PLANNING CONSULTATION RESPONSE

Application No	2025/1077
Proposal	Change of use from dwellinghouse (Class C3) to 4-bed 4-person HMO (Class C4) (Amended Description).
Address	329 Midland Road, Royston, Barnsley, S71 4AZ
Date of Consultation Reply	05.01.26
Consultee	Stacey Fieldsend-Case Management Officer

Revision	Date	Initials
Client		
Project	PROPOSED CHANGE OF USE 329 MIDLAND ROAD, ROYSTON, BARNSELY, S71 4AZ	Project No. 2693
Drawing	SCHEME PROPOSAL EXISTING AND PROPOSED FLOOR LAYOUTS	Drawing No. P.100
Drawn	Scale @ A1 1:50	Revision -
Check	Date 02.12.2025	
SW

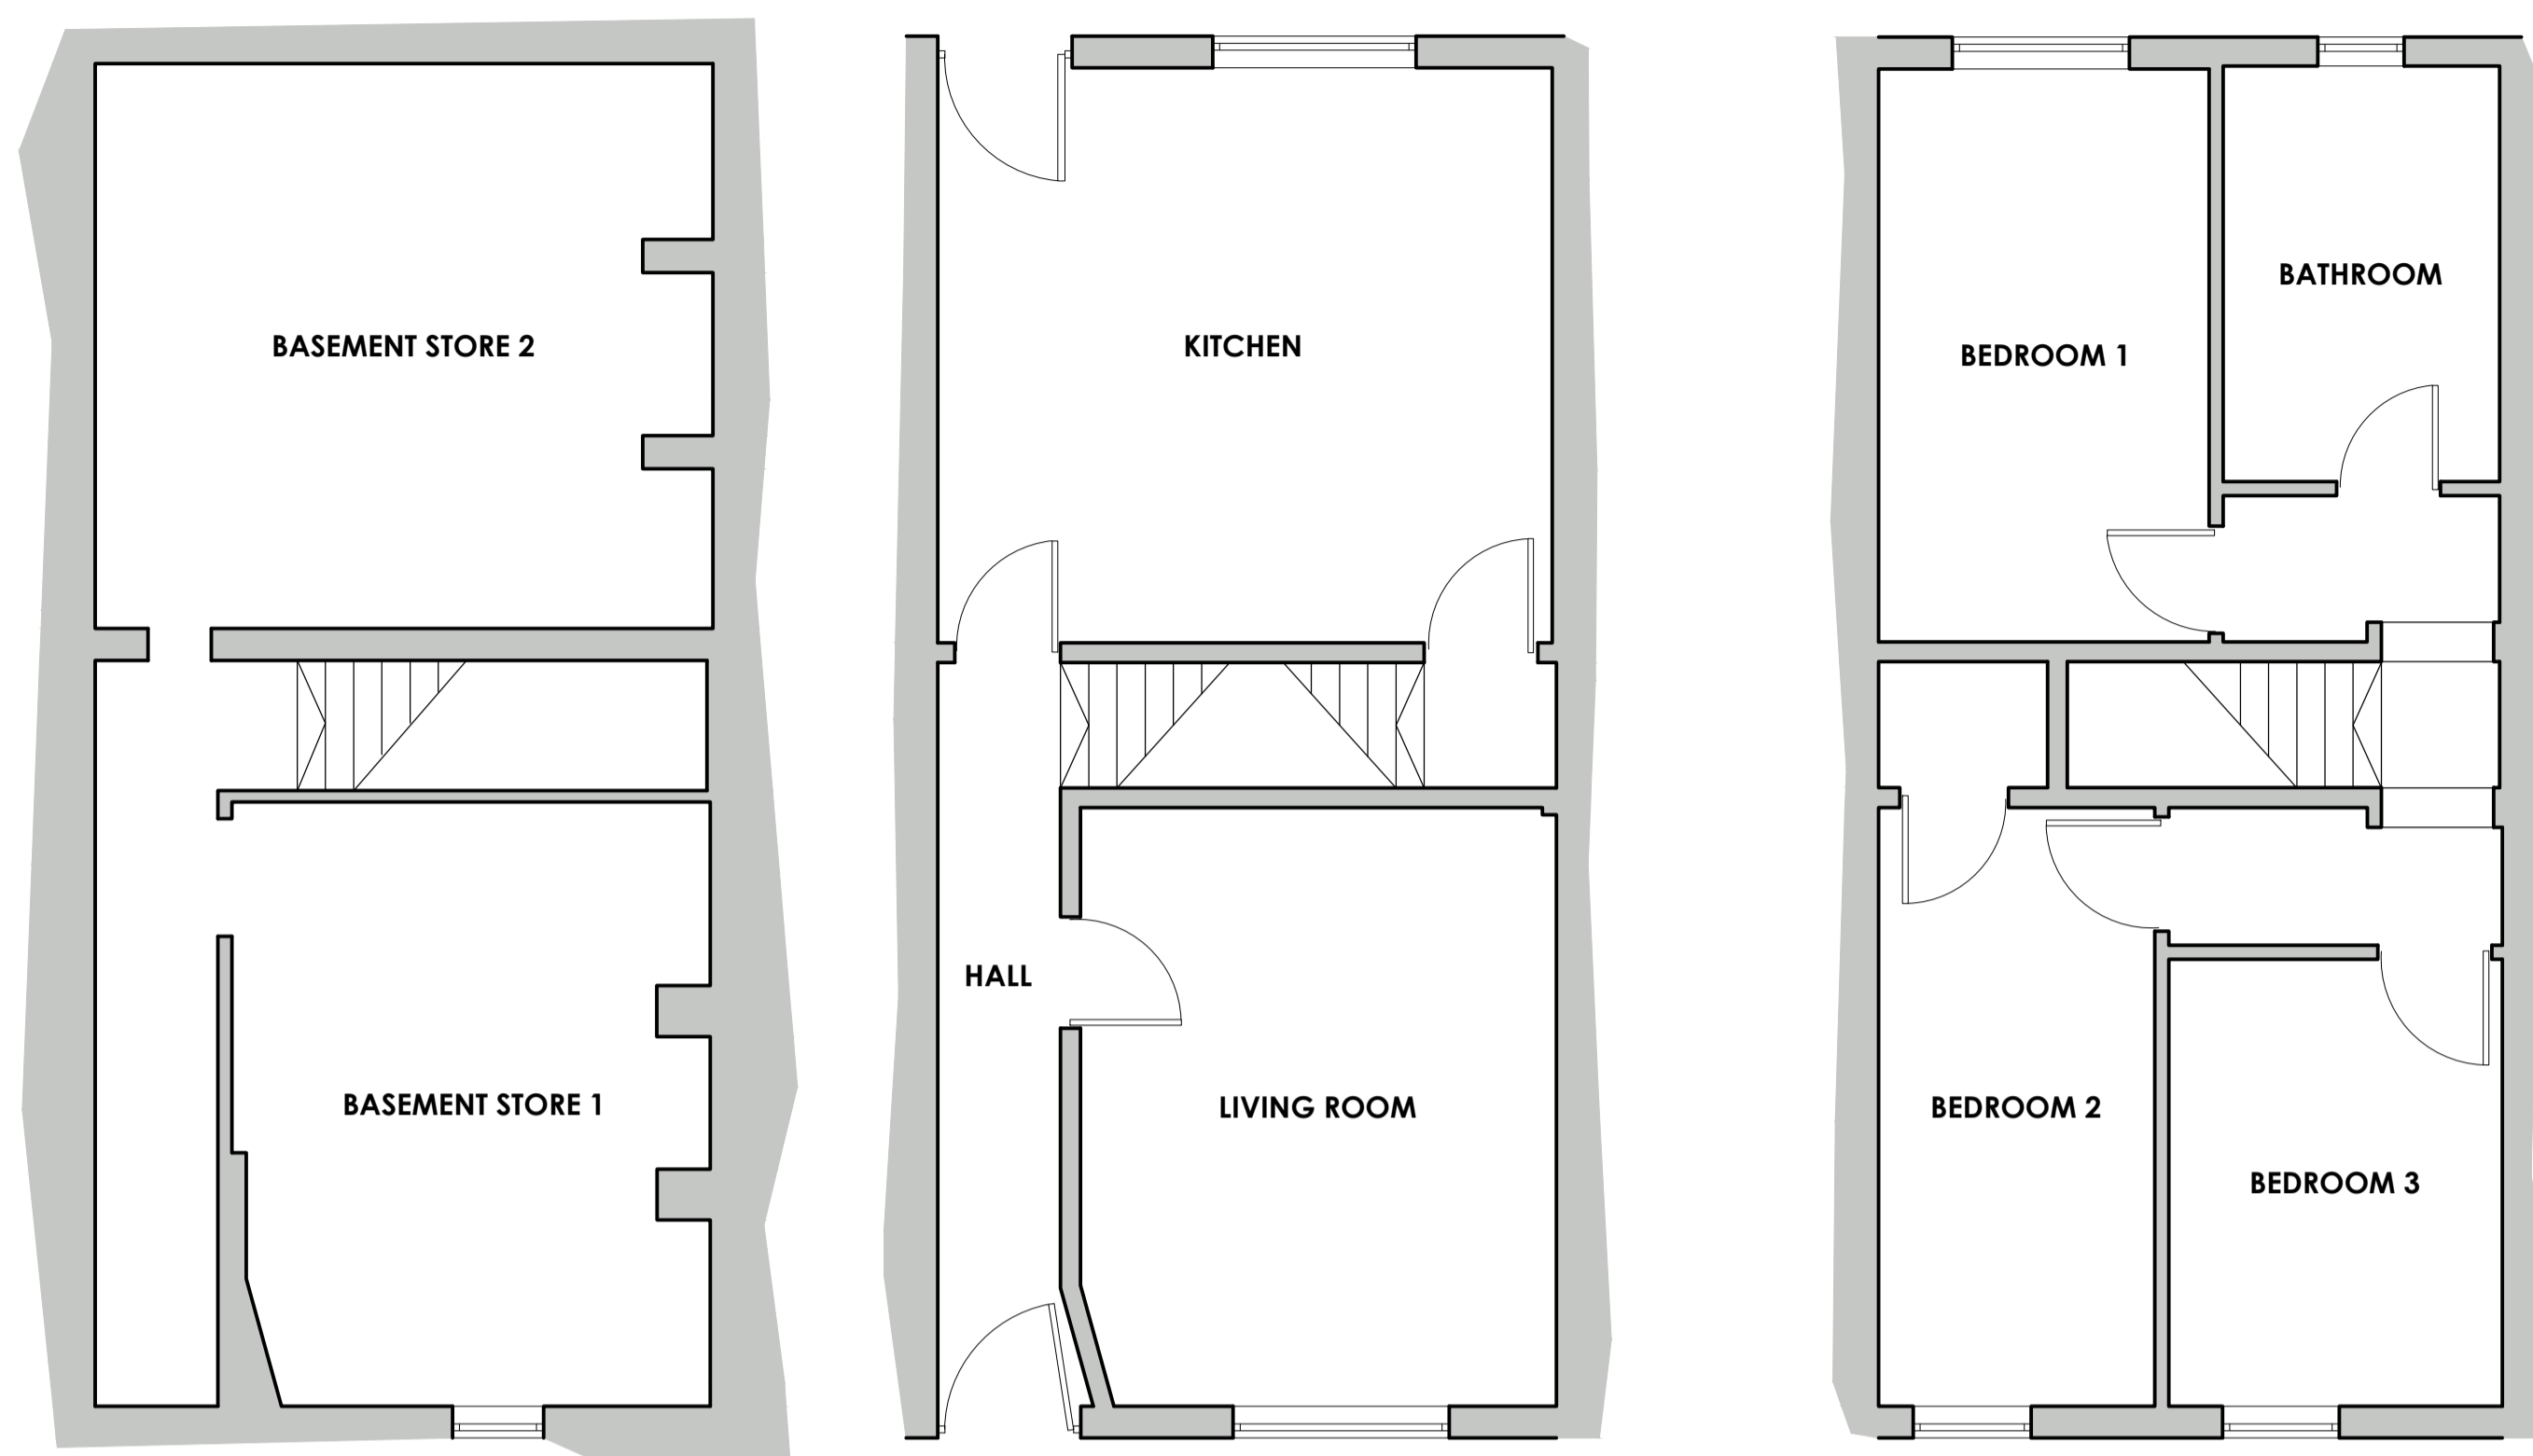
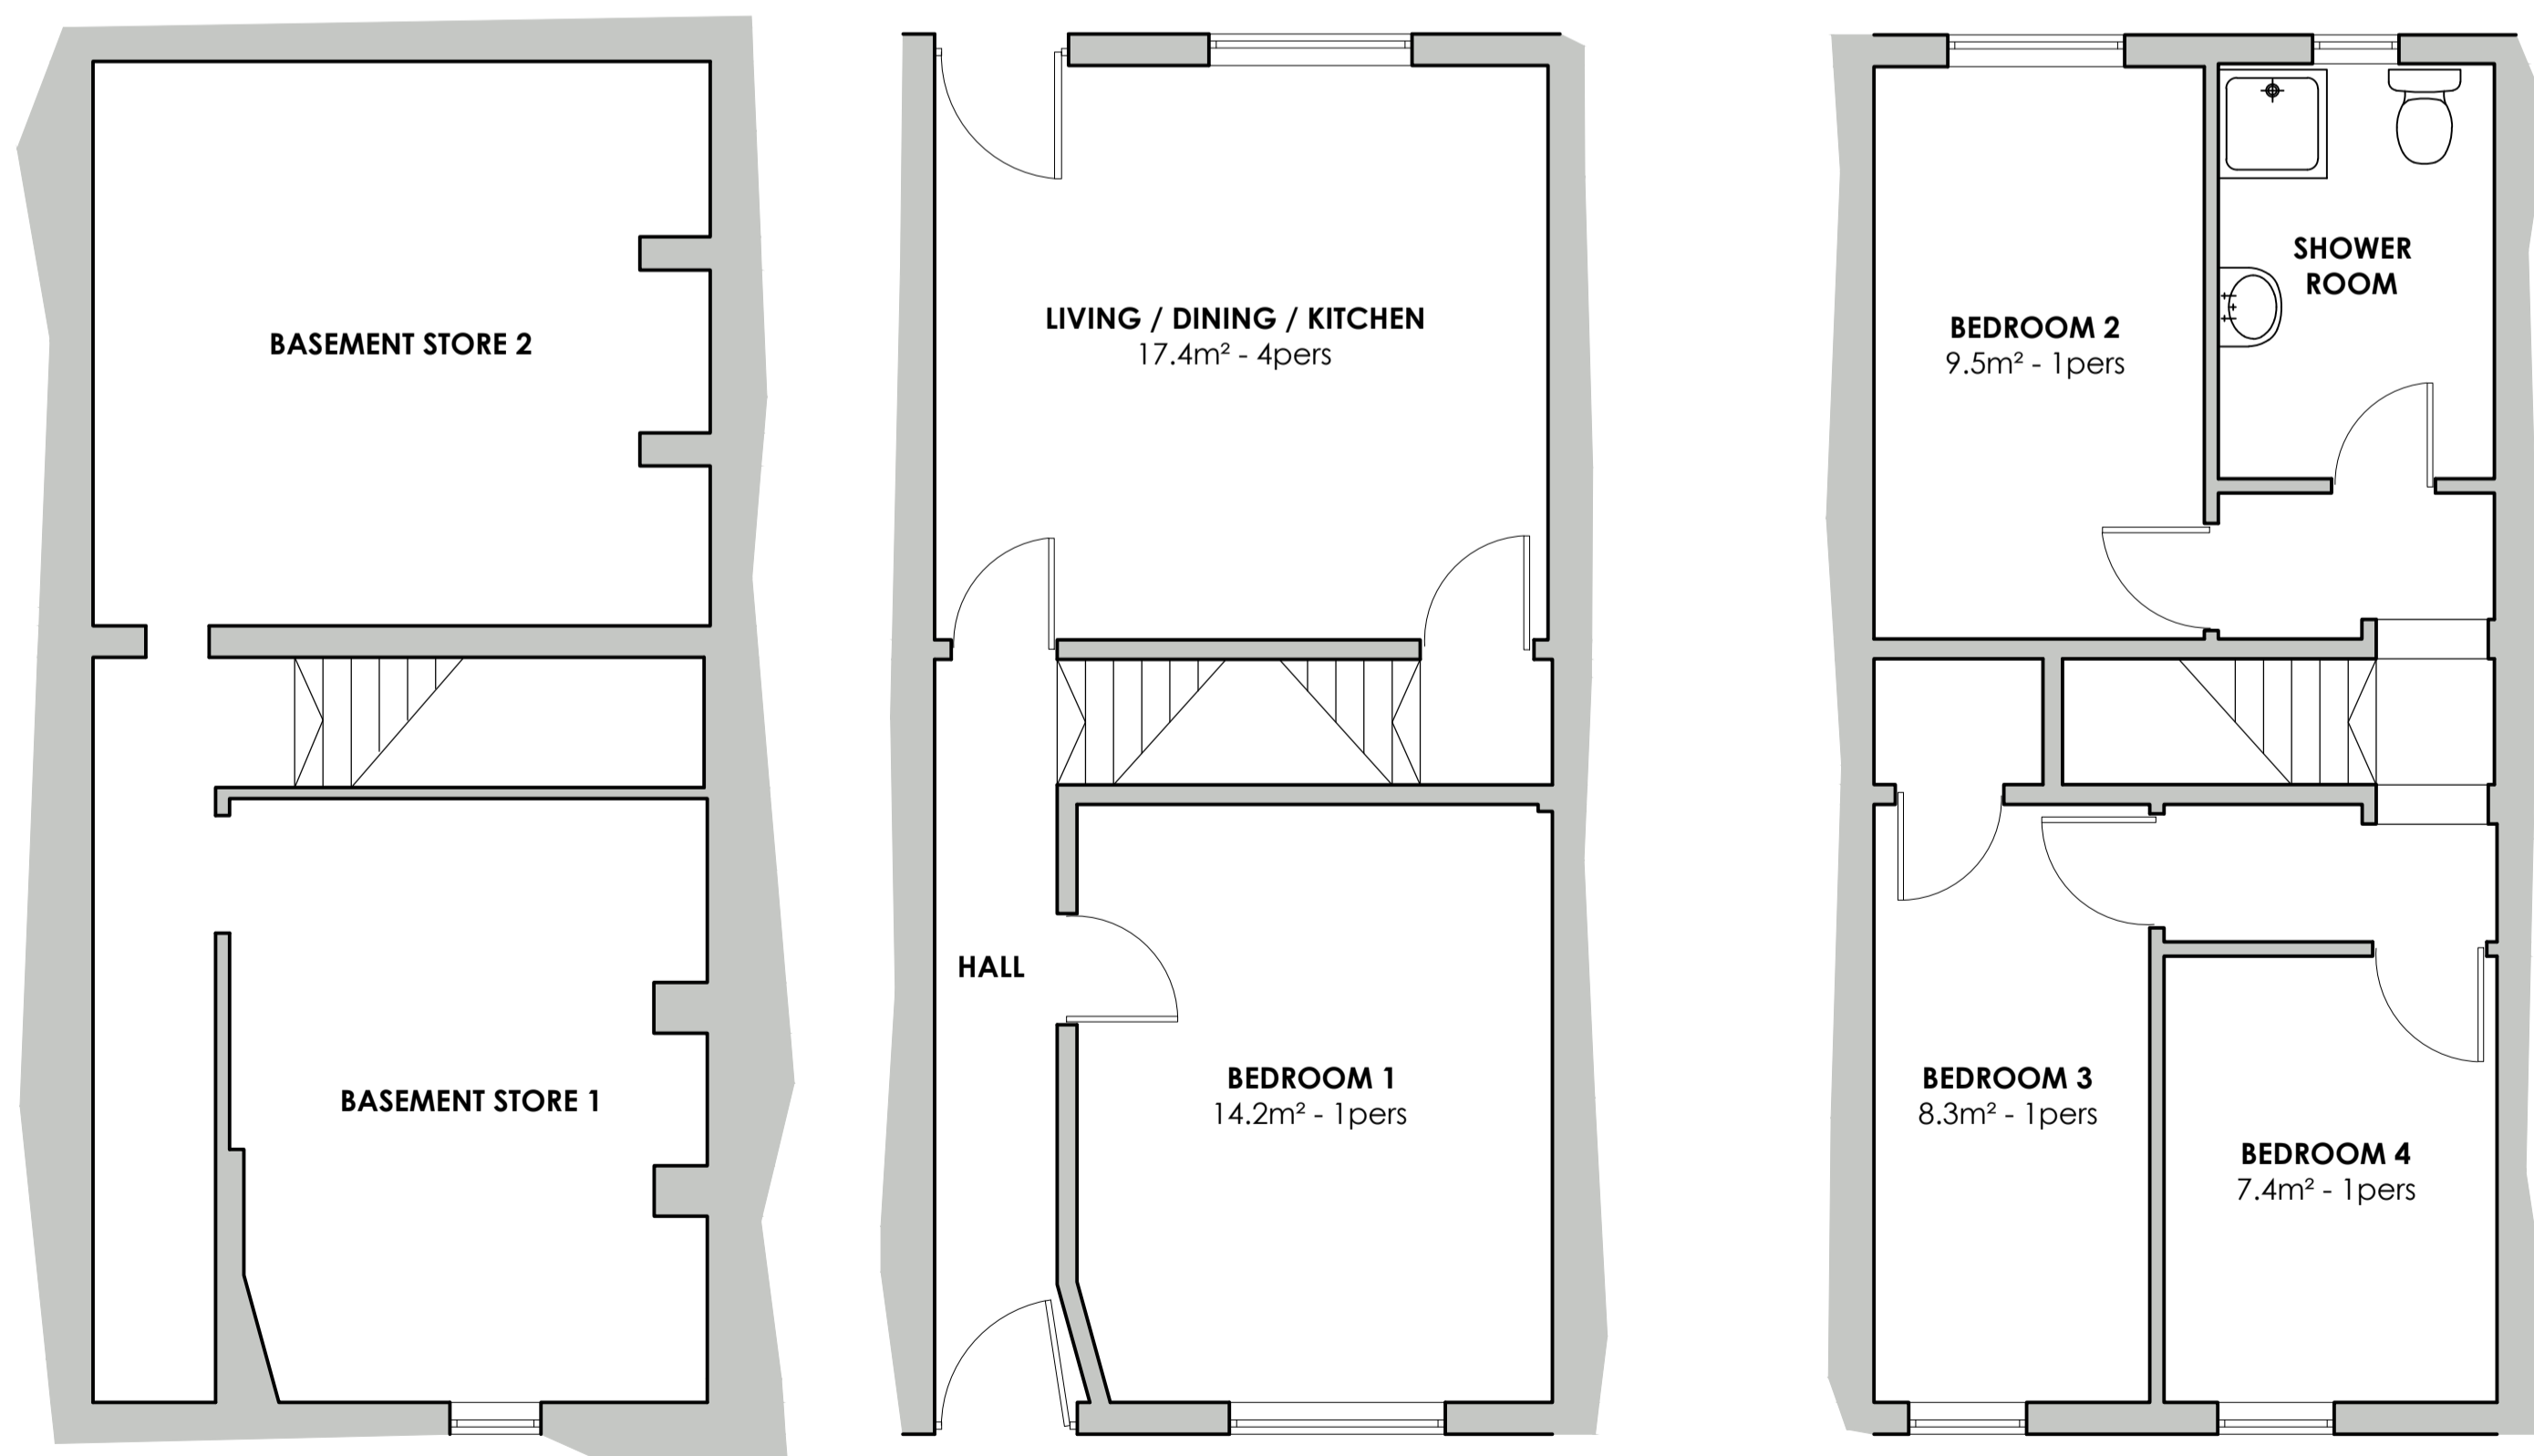
The bedrooms on the first floor are all under 10.22sq metres, therefore a **separate** living room will be required in addition to the kitchen/dining room. A combined kitchen/diner/living room does not qualify as communal living space.

I oppose the use of the ground floor room as a bedroom and would insist that it remains a living room.

I will approve use of the property as a 3 bed HMO only.

The ground floor front room remains as a living room at all times.
